Hunter Indoor Sports Centre (SSD-65595459) – Environmental Impact Statement

Attachment 1 - BCS Assessment Summary for Hunter Indoor Sports Centre Environmental Impact Statement (SSD-65595459)

14683 - DA - A41 - Rev B - 16 August 2024  
Confidential. Copyright EJE Architecture. Nominated Architect - Bernard Collins No. 4438 (NSW ARB)  
Filename: 14683-SSDA-HISC (12-08-2024).pln

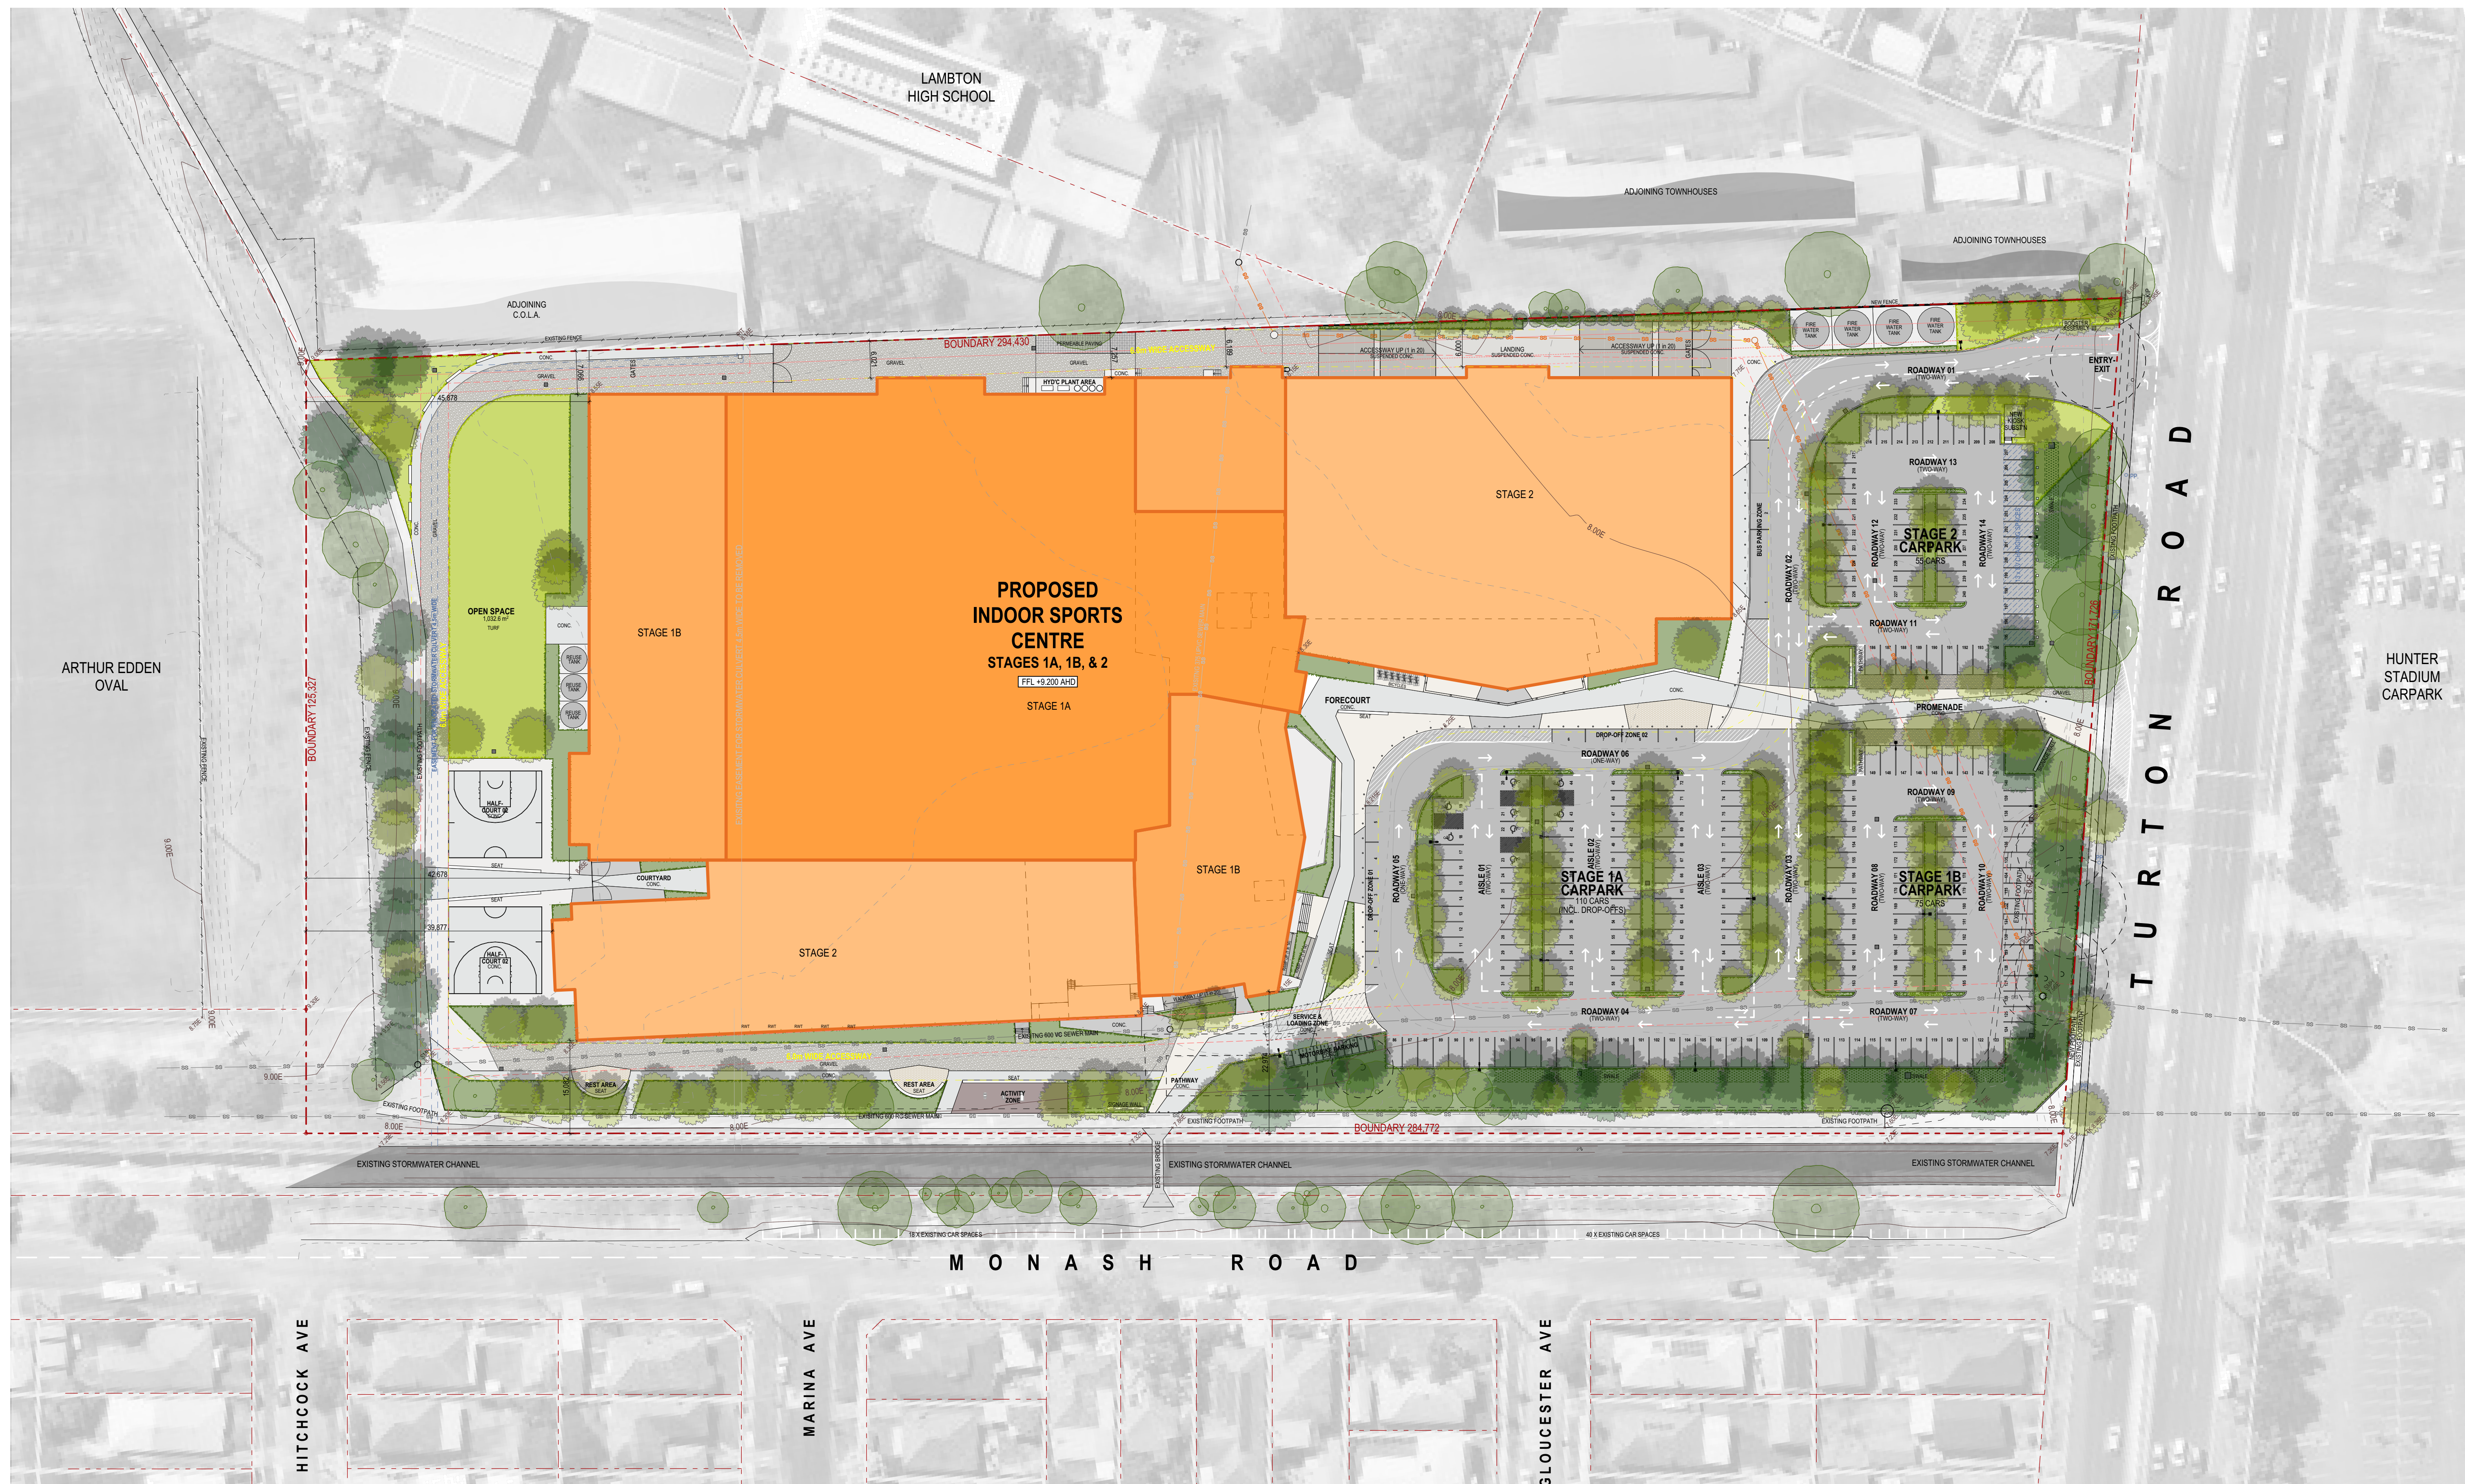
5.	<i>The risk of cars becoming mobile and blocking drains has not been assessed</i>	The proposed car park is situated within an identified floodway, in close proximity to Kar-rai Creek. This location poses a significant risk of vehicles being swept into the creek or other drainage channels during flood events. Such occurrences can lead to severe blockages of culverts, causing substantial upstream flooding and potential hazards to life and property. The Newcastle City-wide Floodplain Risk Management Study and Plan (N-FRMSP) highlights the critical nature of this issue. The report cites numerous instances of debris, including cars, blocking drainage infrastructure during past flood events. For example, in the lower reaches of Cottage Creek, Newcastle West, two shipping containers obstructed culverts, exacerbating flood impacts. To mitigate this risk, the N-FRMSP recommends implementing measures such as installing bollards around flood-prone car parks or along channel edges to prevent vehicles from entering waterways. Newcastle City-wide Floodplain Risk Management Study and Plan: Figure 3-2 Car in channel at Federal Park, Wallsend

<i>Newcastle City-wide Floodplain Risk Management Study and Plan: Figure 3-2 Car in channel at Federal Park, Wallsend</i> Recommended action: <i>Evaluate the risk and potential impact to property and life upstream of the stadium from vehicle-related blockages of channels and culverts.</i>
	<i>Extent and Timing</i>	Pre-determination
